TR010064: Application by National Highways for the M60/M62/M66 Simister Island Interchange Project

The Examining Authority's Written Questions and requests for further information

Issued on 22 October 2024

Reproduced by permission of Ordnance Survey on behalf of HMSO.
 © Crown copyright and database right 2022. All rights reserved.
 Ordnance Survey Licence number 100030649.

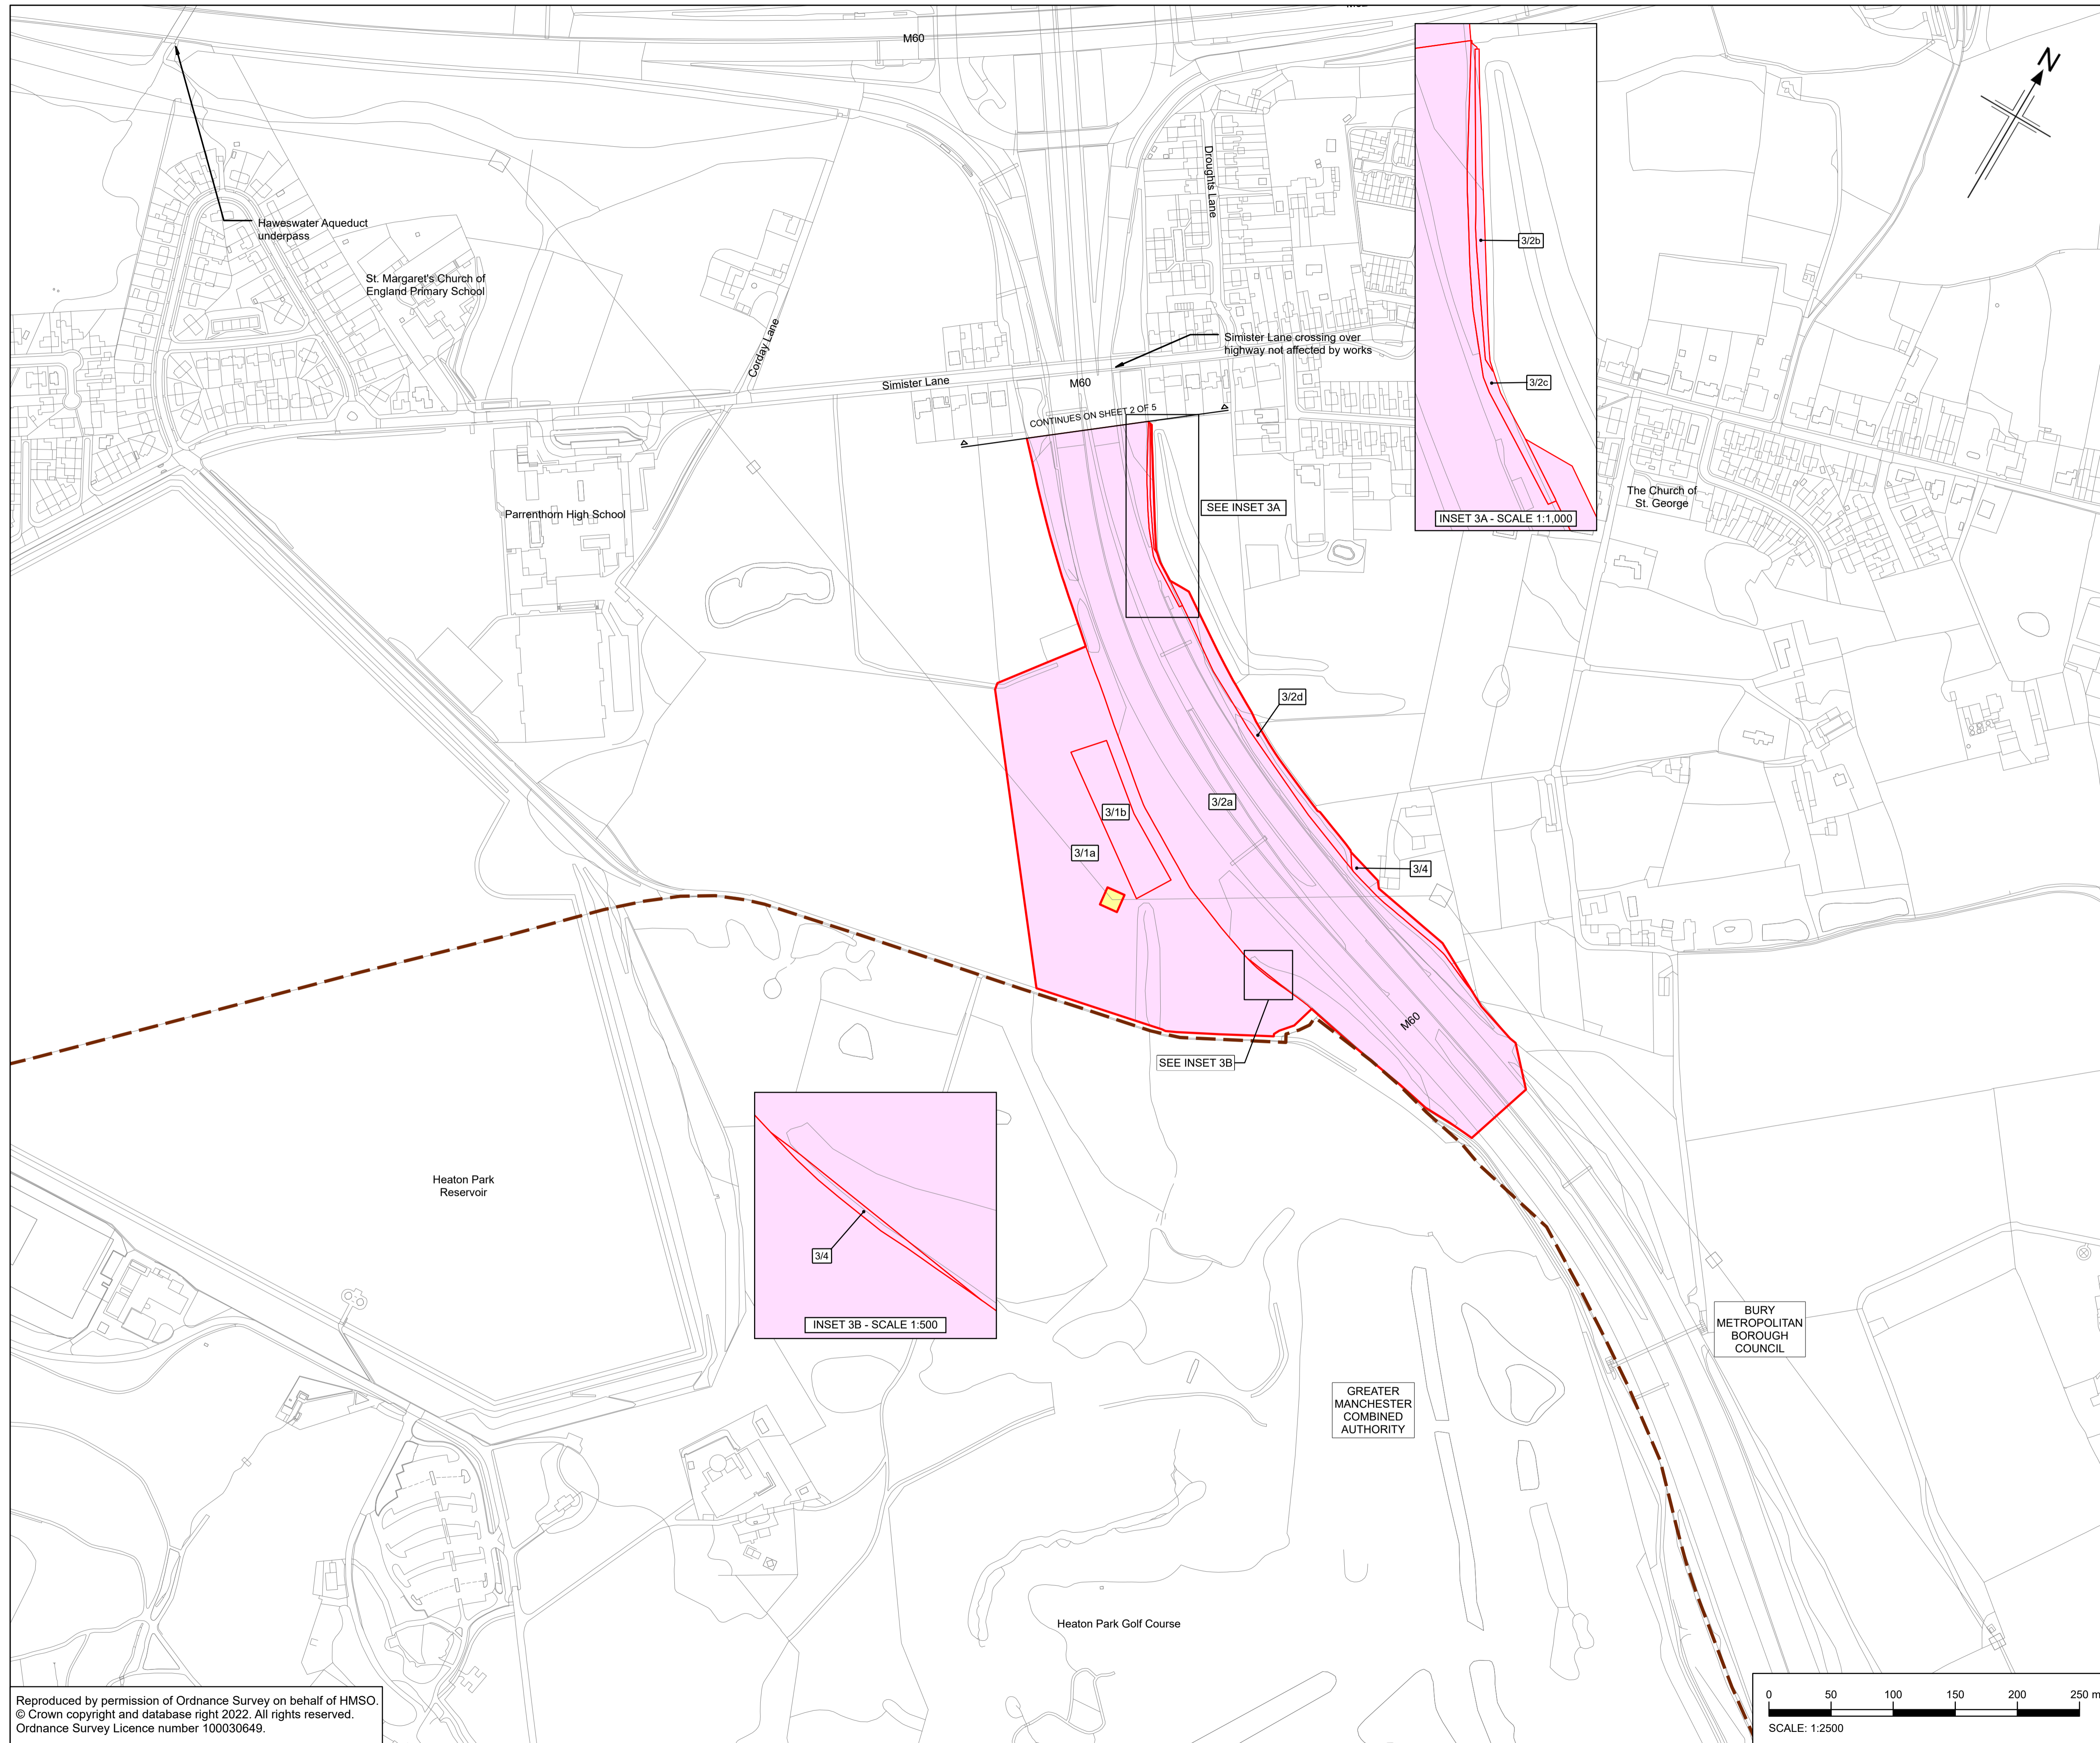
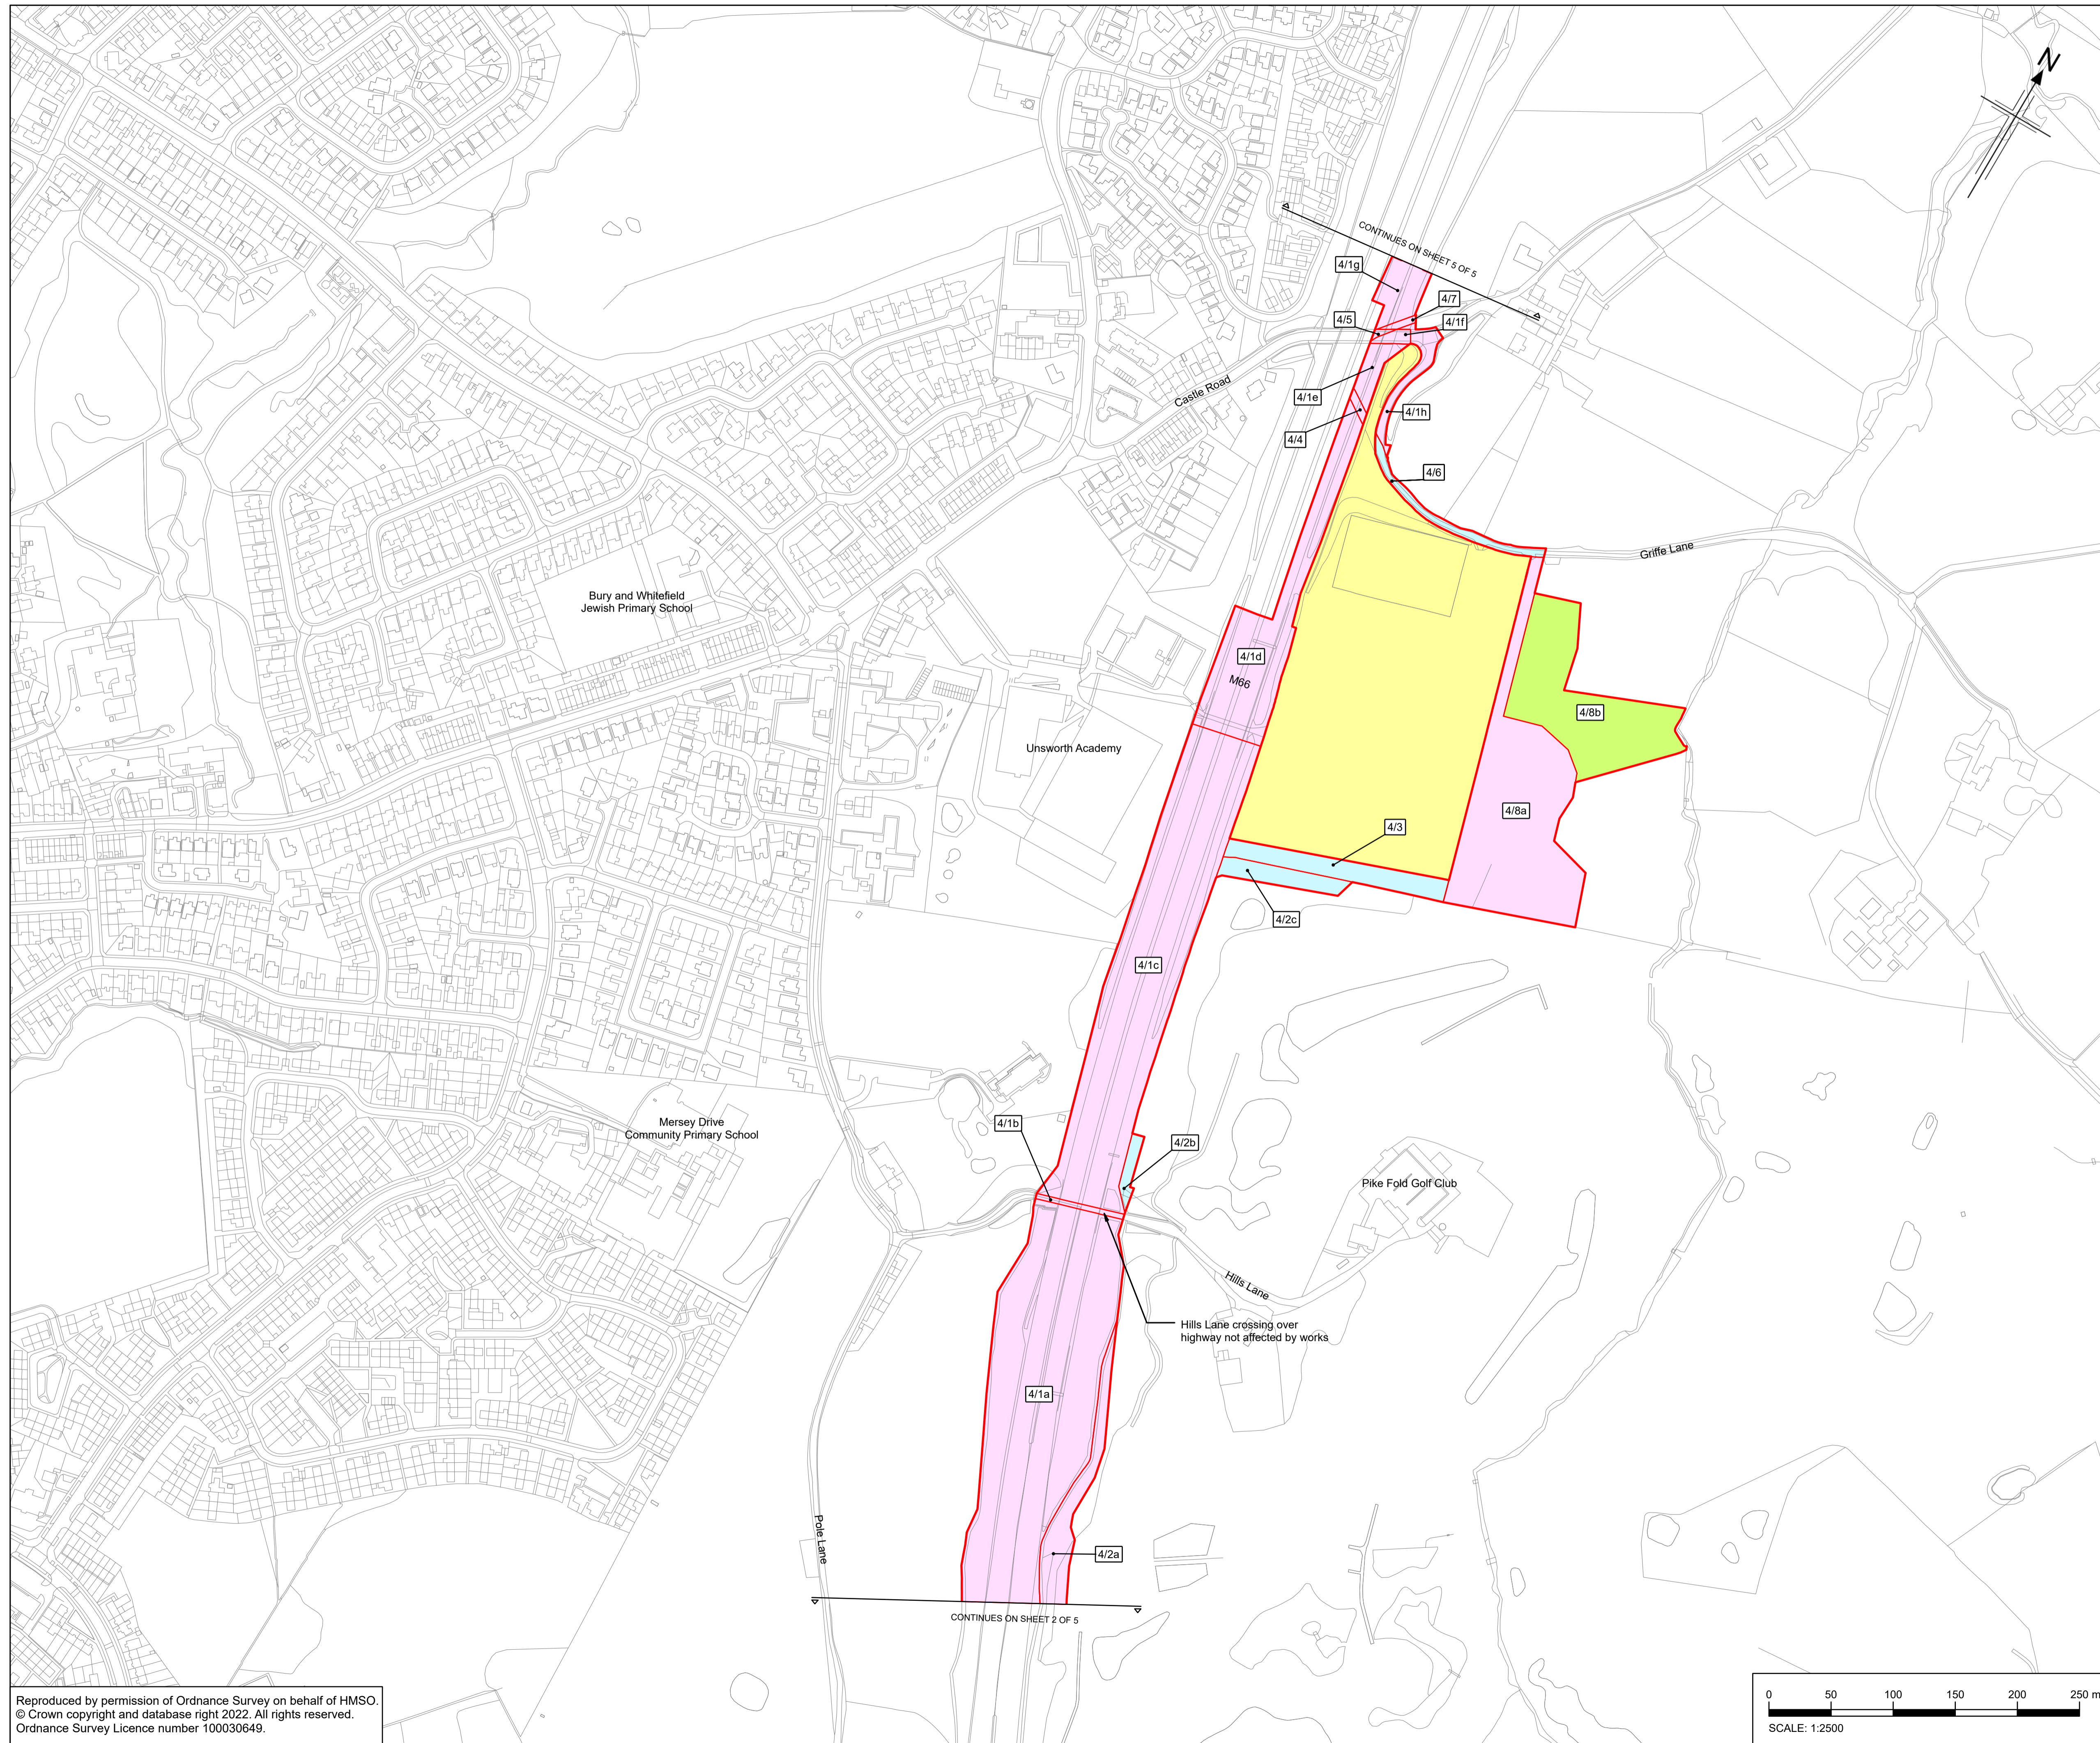
ExQ1	Question to:	Question
CA.1.2	Applicant	<p>Category 3 Persons</p> <p>The Statement of Reasons (SoR) [APP-019], Section 4.7 briefly covers the assessment of Category 3 persons explaining that it was based on a worse-case assessment. The process is described in the BoR [AS-010].</p> <ol style="list-style-type: none"> i. Please provide further details of the process for identifying Category 3 persons. ii. Please provide a map showing the locations of Category 3 persons. iii. Explain why the assessment can be considered 'worse-case'.
CA.1.3	Applicant	<p>Unknown/Unregistered Land</p> <p>Diligent enquiry into land interests: Could you summarise where you have not yet been able to identify any persons having an interest in the land, including any Rights over unregistered land? What further steps will you be taking to identify any unknown Rights during the Examination?</p>
CA.1.4	Applicant	<p>Land Plans</p> <p>There is no plot 3/3 but there are two plots marked 3/4 on the Land Plans [AS-005]. Please correct.</p>
